23 September 2025

Hunter Transmission Project (SSI-70610456)
Yancoal Australia Ltd Submission

YANCOAL
 新加坡大和有限公司
 MT THORLEY WARKWORTH
 Hunter Transmission Project Alignments

Figure 1

Hunter Transmission Project
Figure 1.1

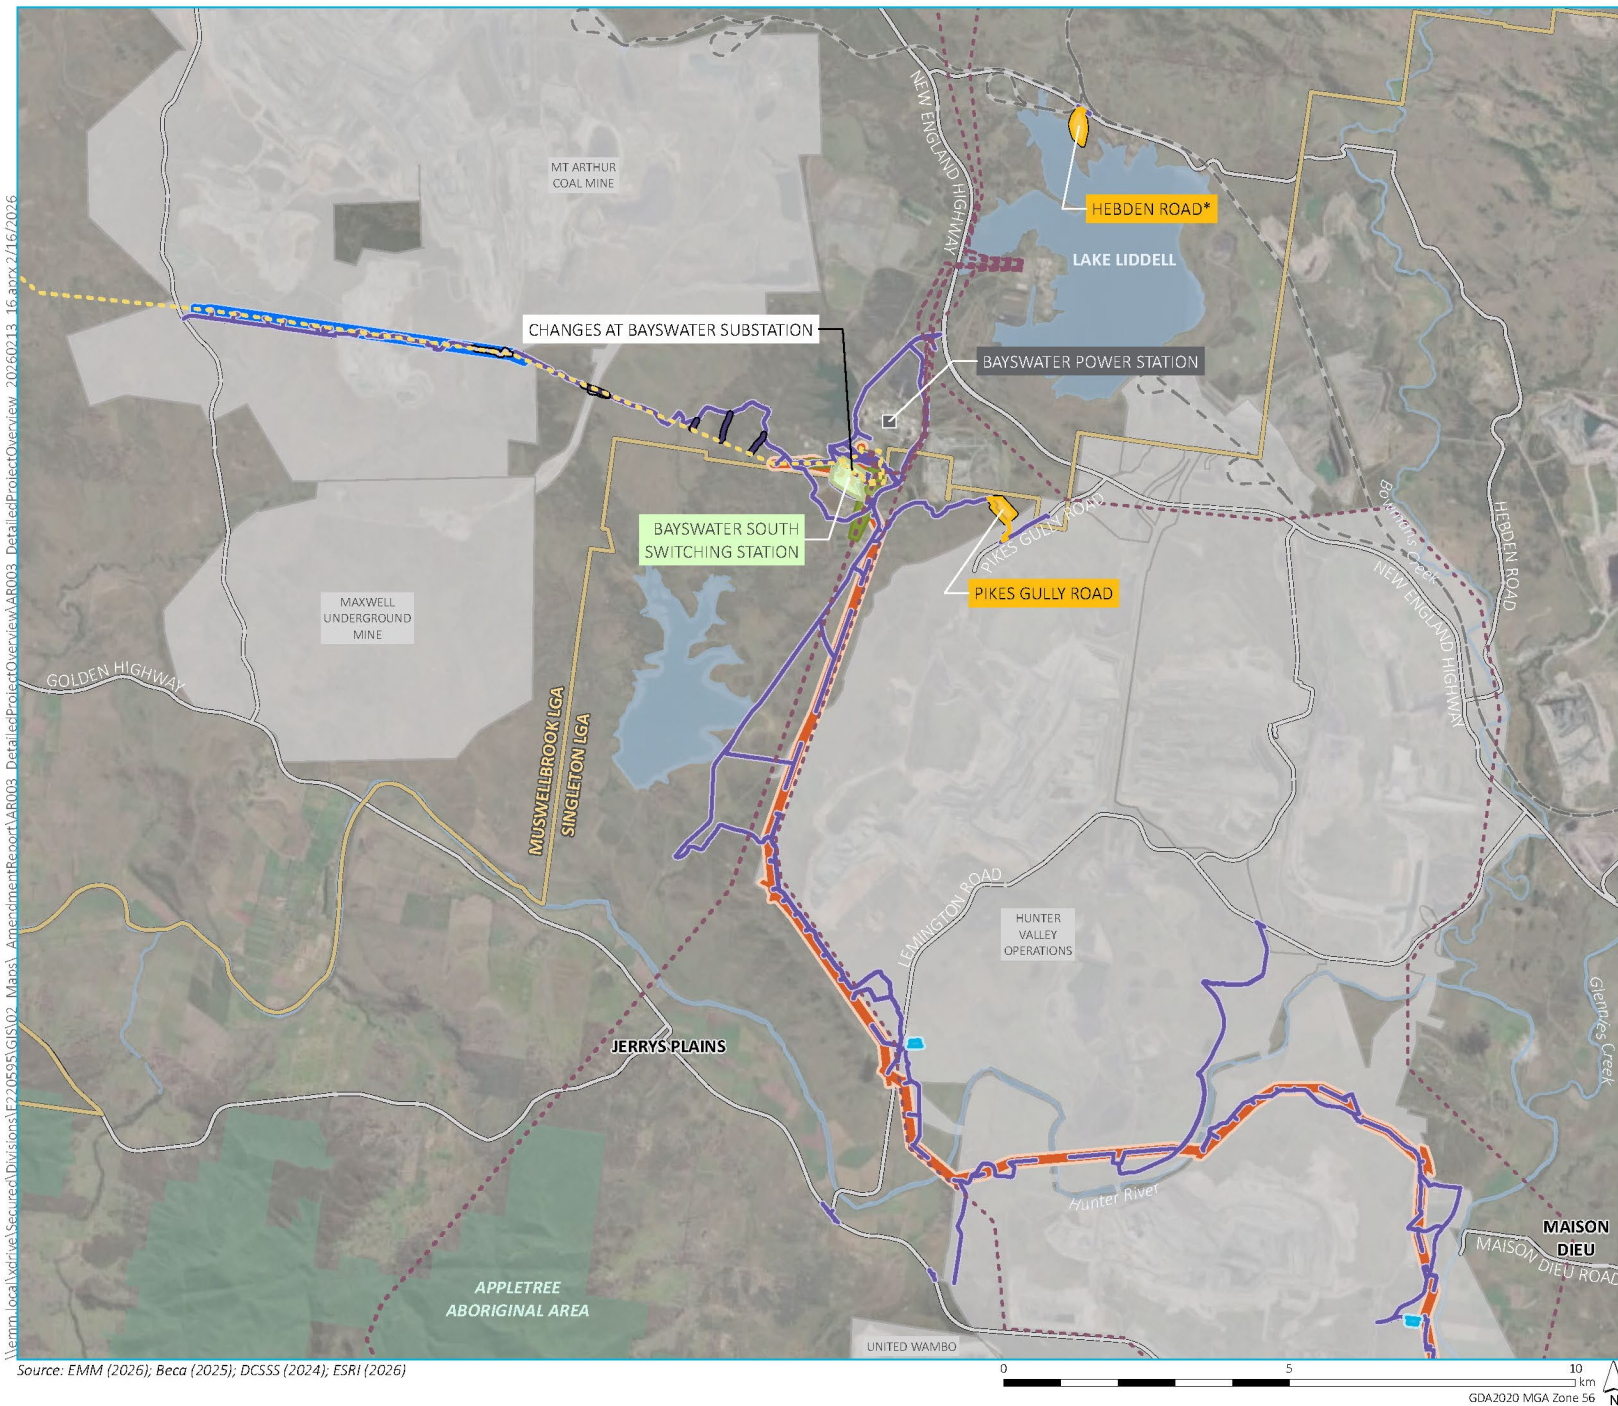
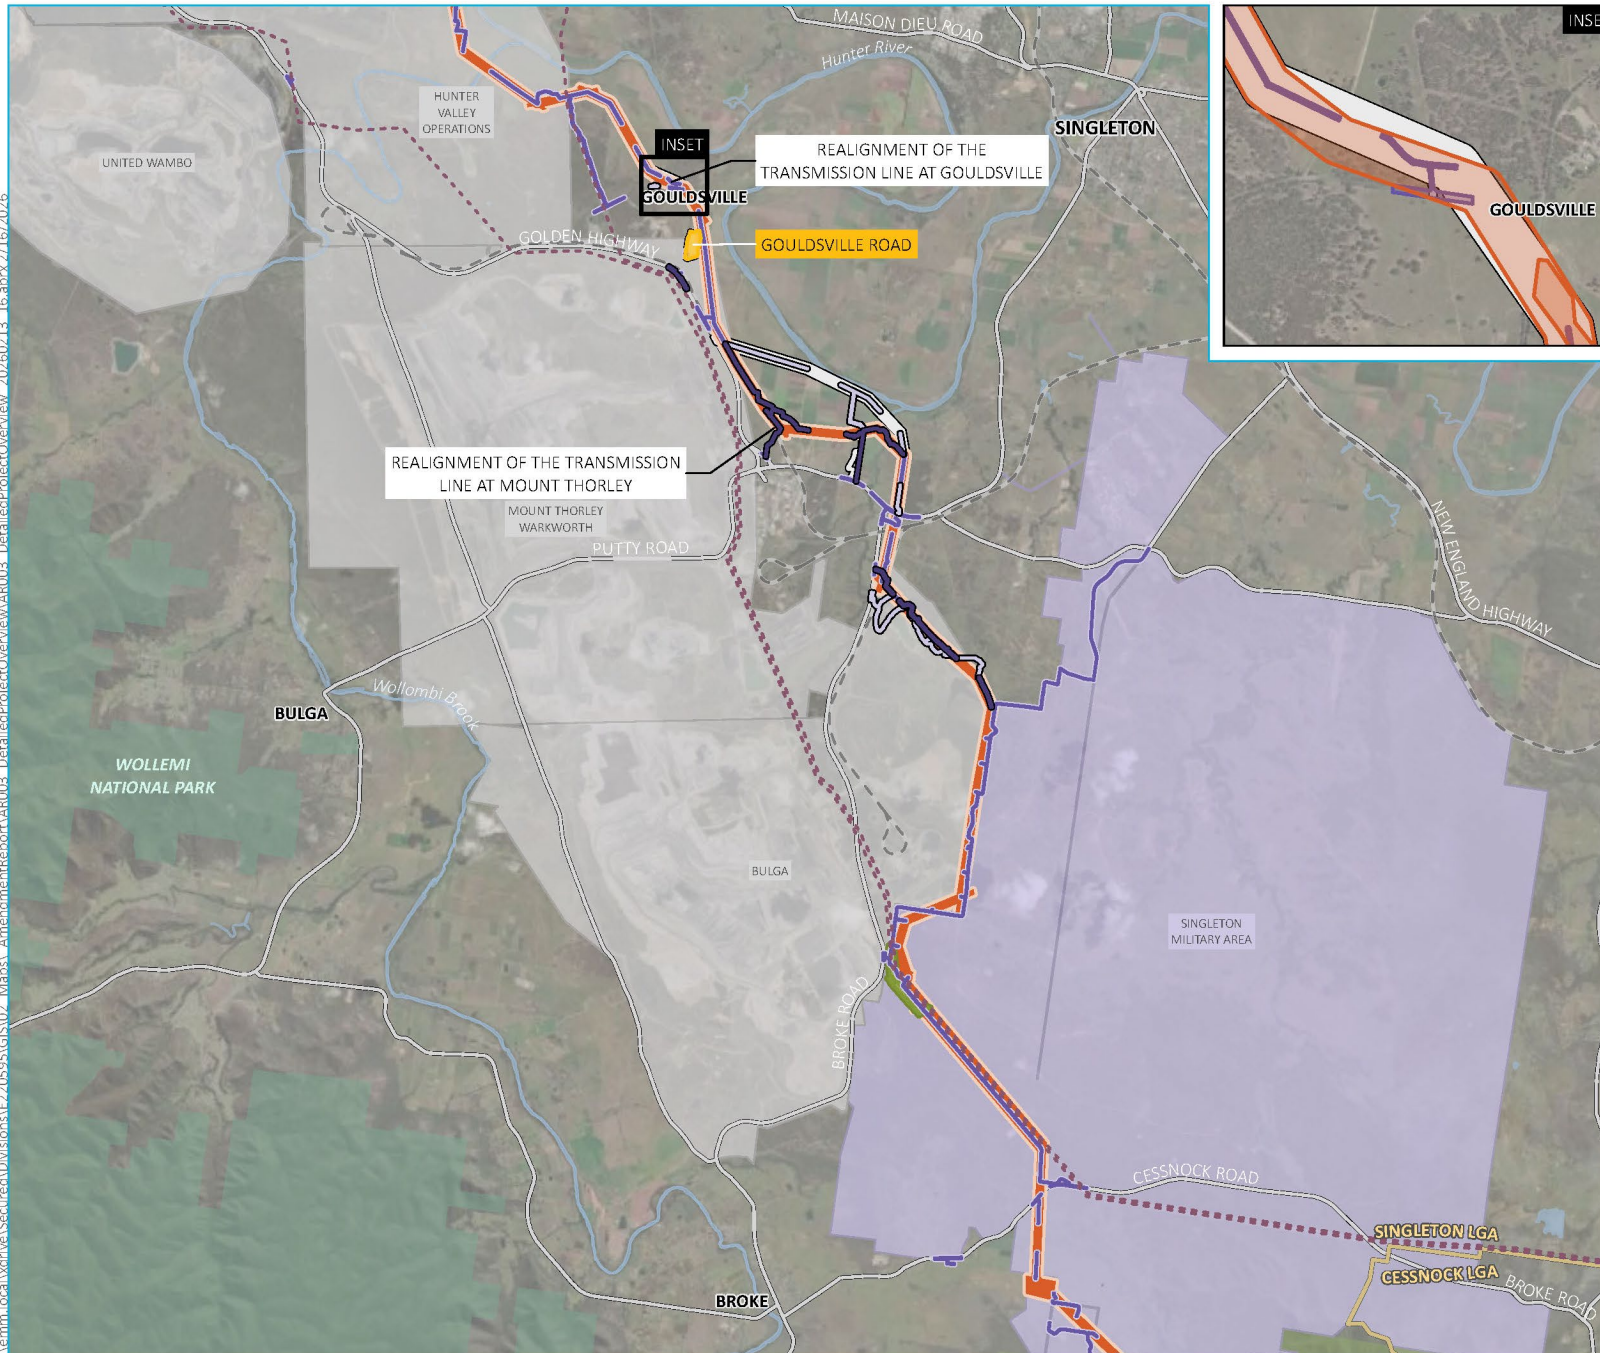
- 2.4 The Transmission Infrastructure alignment which intersects land owned by MTW entities as presented in the CSSI Application EIS on public exhibition (referred to as the **EIS Alignment** in this submission) is not consistent with the Agreed Alignment. Additionally, the EIS provides a number of discontinued Transmission Infrastructure alignment options (Map 2 of Figure 3.8 of the CSSI Application EIS). A comparison of the Agreed Alignment and the EIS Alignment and discontinued alignment options within land owned by MTW entities is presented in Schedule 2 of this submission.

- (c) Section 12.3.3 of the CSSI Application EIS (page 547) provides that the “*project has been refined based on engagement with landowners to minimise impacts on agriculture*”. Additionally, Section 3.6.2 of the CSSI Application EIS (page 91) provides that “*refinements within Mount Thorley-Warkworth Mine land, adjacent to the Golden Highway, shifted the transmission line alignment away from the Hunter River, further west*”, appearing to refer to the Agreed Alignment. These “refinements” are not reflected in the EIS Alignment presented in the CSSI Application EIS. EnergyCo will need to resolve the discrepancies between the EIS Alignment and the Agreed Alignment prior to approval.
